**Cotswolds
National
Landscape**

PINS REFERENCE NO: EN010168

DESCRIPTION: Development consent to construct, operate, maintain and decommission a solar photovoltaic (PV) generating station, with a generating capacity of more than 50 megawatts (MW) and associated infrastructure

LOCATION: Lime Down Solar Park, Wiltshire

Title:
Figure 4-4: Main Infrastructure Layout Changes between PEIR and DCO Application

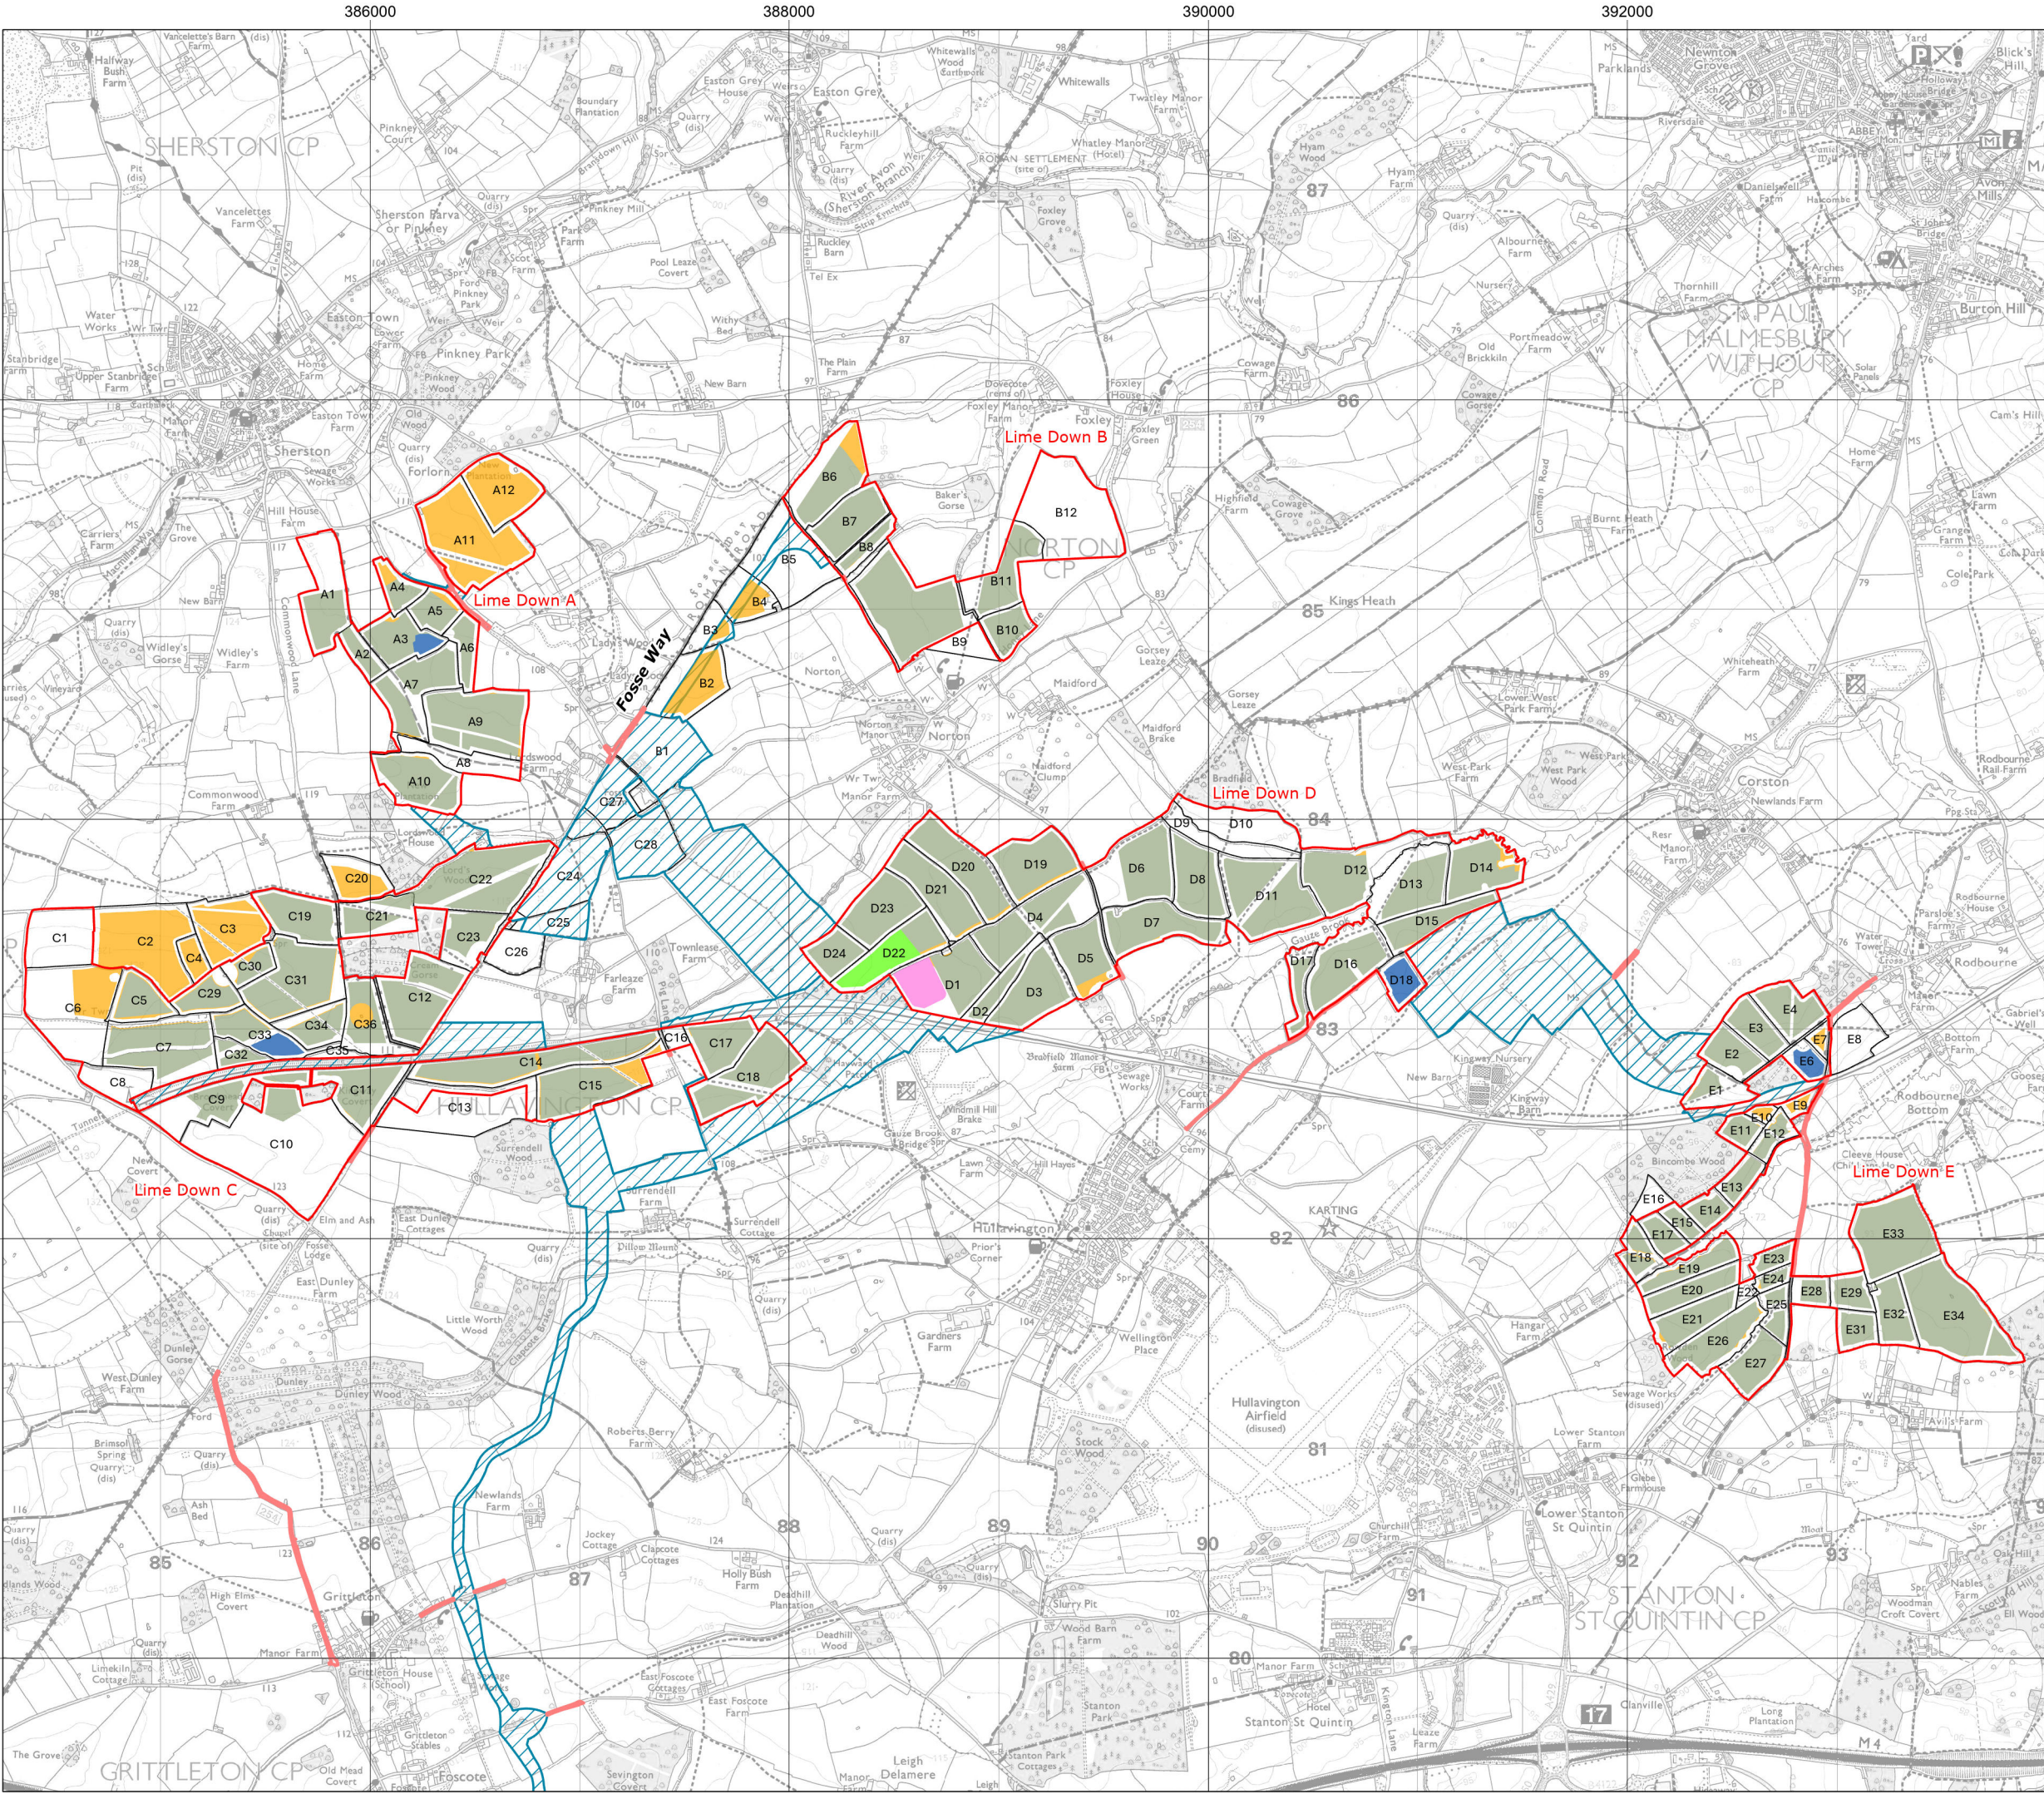
This PMIE concerns the nature and scale of visual effects of Site C of the Scheme on receptors located on Alderton Road which forms the boundary with the CNL. The Board had previously recommended the potential removal of panels from fields C7 and C9 pending the results of further assessment.

The Board understands from a voicemail message left for its Planning Officer by the Applicant on 18 May 2026 that, following discussions at the meeting on between the Applicant and the Board on 30th March 2026, the Applicant is willing to remove Solar PV panels from the remainder of Field C9 if a formal request is made by the Board to the Examining Authority. The Board's Planning Officer confirmed via email to the Applicant on 28 May 2026 that this request would be made. Therefore, the Board requests that panels should be removed from the remainder of Field C9 to minimise the impact of the Scheme on views from the CNL.

As such the Board notes the Applicant's position as outlined within the draft Statement of Common Ground with the Board (May 2026, Revision 1, REP2-029) at Reference 3.1.17 (page 14): *"The final iteration of the Scheme includes the avoidance of panels in the southern part of Field A1, the remainder of Field C6 and Fields C7. These areas are identified for habitat enhancement.... Discussions are ongoing surrounding panels in C9."*

If the Applicant maintains the above position and if the above changes are reflected in the final detailed design and DCO, the Board considers PMIE 6 is capable of being resolved.

Title:
Figure 15-2: Construction Vehicle Emissions
Assessment Road Network

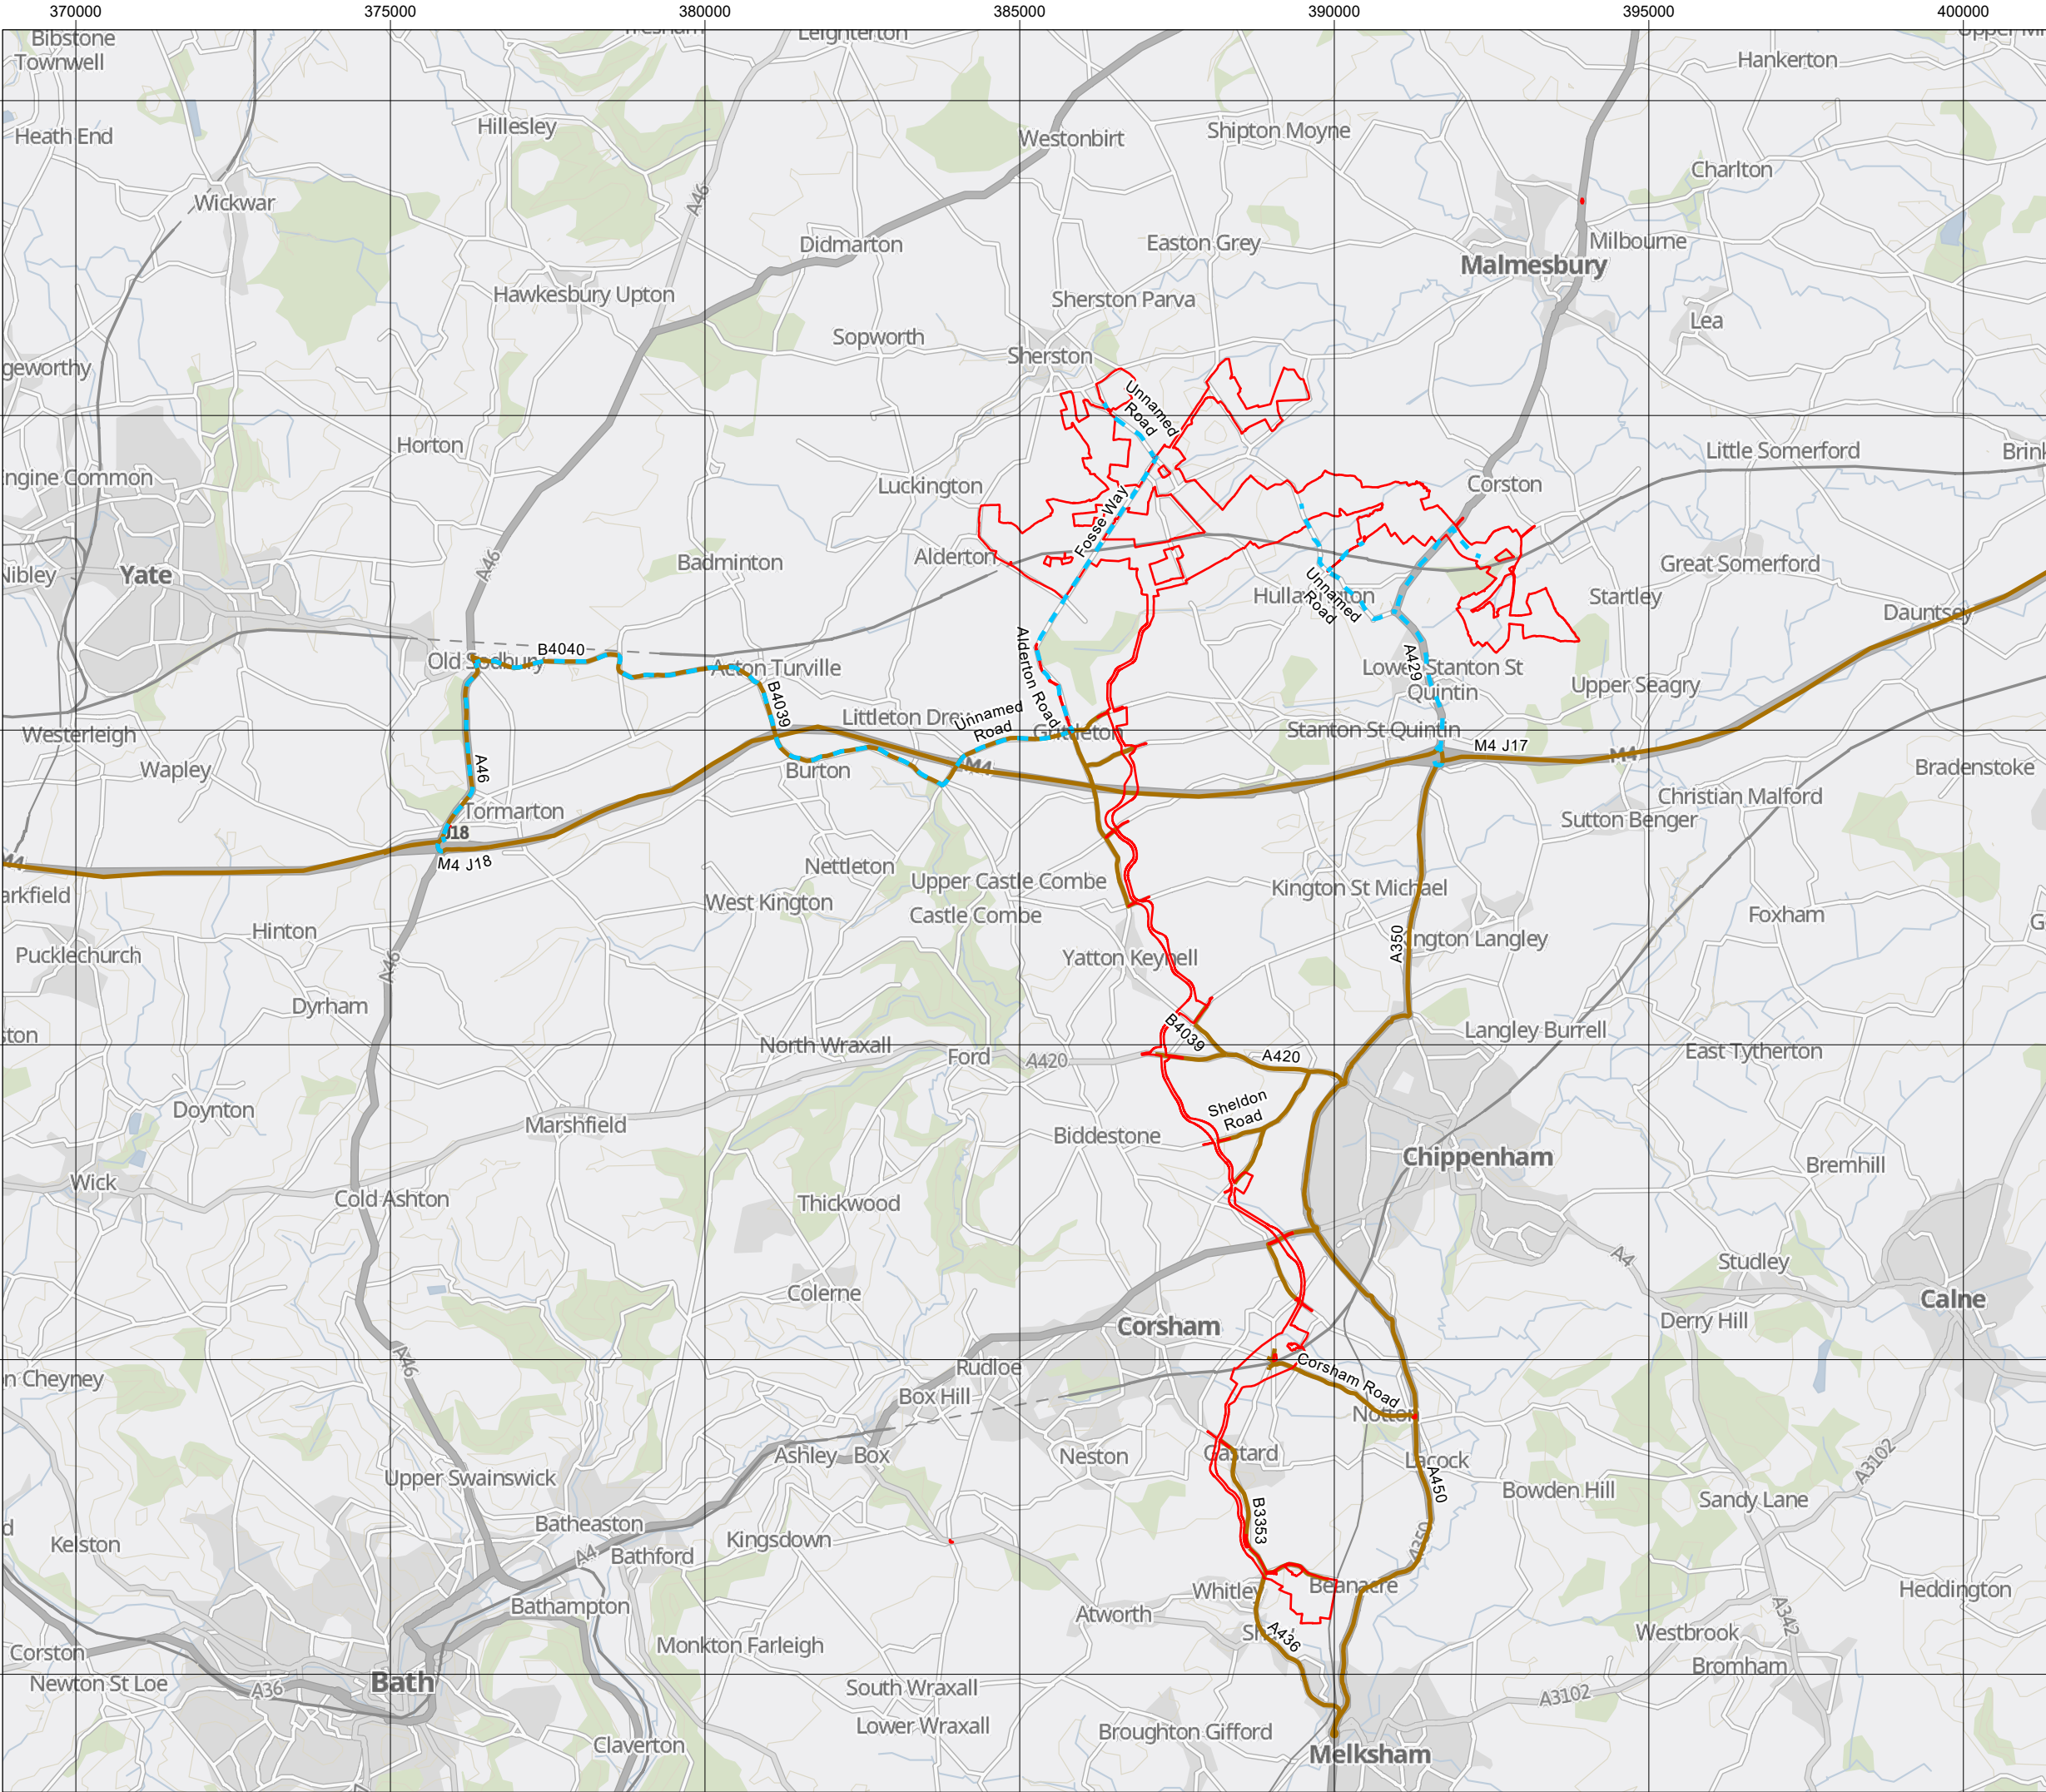
We do not agree with this conclusion. In the Board's view, routing the volume of construction traffic anticipated by the Applicant through the CNL is likely to have a significant adverse effect on its tranquillity, particularly as perceived by an observer when compared to the current baseline condition.

Table 13.24 of the ES shows that total vehicle numbers along much of the 20km route from M4 J18 (i.e. the B4040 (11% change), the Road West of Grittleton (27.9% change), Alderton Road (19.7% change) and the Fosse Way (29.1% change)) would breach the 10% rule of thumb. The latter three sections which experience the greatest increases are the parts of the route which currently exhibit greatest levels of tranquillity.

Additionally, Table 13.25 of the ES shows that the number of HGVs would breach the 30% rule of thumb for the entire route, save for the short stretch of the A46 from M4 J18 to the junction with the B4040. The B4040 would see a 68.5% increase in HGV traffic, the B4039 a 75.8% increase, the minor road west of Grittleton a 102.0% increase, Alderton Road a 250% increase and the Fosse Way a 238.1% increase.

Regardless, even the Applicant's lower estimates are significantly more than both 'rules of thumb' for HGVs and the Rule 2 for sensitive areas for total traffic flows. As such the Scheme does not accord with the Board's guidance and by extension Policy CE5 of the CNL Management Plan and also Policy 51 of the Wiltshire Core Strategy.

The Board considers that construction traffic of the levels described above travelling along the proposed route through the CNL is likely to result in significant direct adverse effects on the CNL in respect of impacts on landscape character and visual qualities as well as tranquillity. Due to the nature of the route and the type of vehicles involved, particularly HGVs and AILs, the Board considers that construction traffic is highly likely to cause physical damage to, and / or lead to the temporary and / or permanent loss of roadside landscape elements such as overhanging trees, hedges, verges, banks, and ditches and possibly damage structures such as walls and bridges. This would conflict with Sections 9.14 and 11.13 of the Cotswolds AONB Landscape Strategy & Guidelines, and by extension Policies CE1 and CE13 of the CNL Management Plan, Policy 51 of the Wiltshire Core Strategy and paragraph 189 of the NPPF.

In conclusion, and notwithstanding the mitigation measures proposed by the Applicant to address the impacts of construction and decommissioning traffic, the Board considers that by routing this significant amount of traffic through the CNL, the Scheme would give rise to a ***direct, major/moderate (significant) adverse*** effect on the tranquillity of the CNL, one of its special qualities. Whilst it is acknowledged that in EIA terms, this impact would be 'temporary' (i.e. not permanent), it would still last for several years and for its duration, the impact would be significant, direct and adverse.
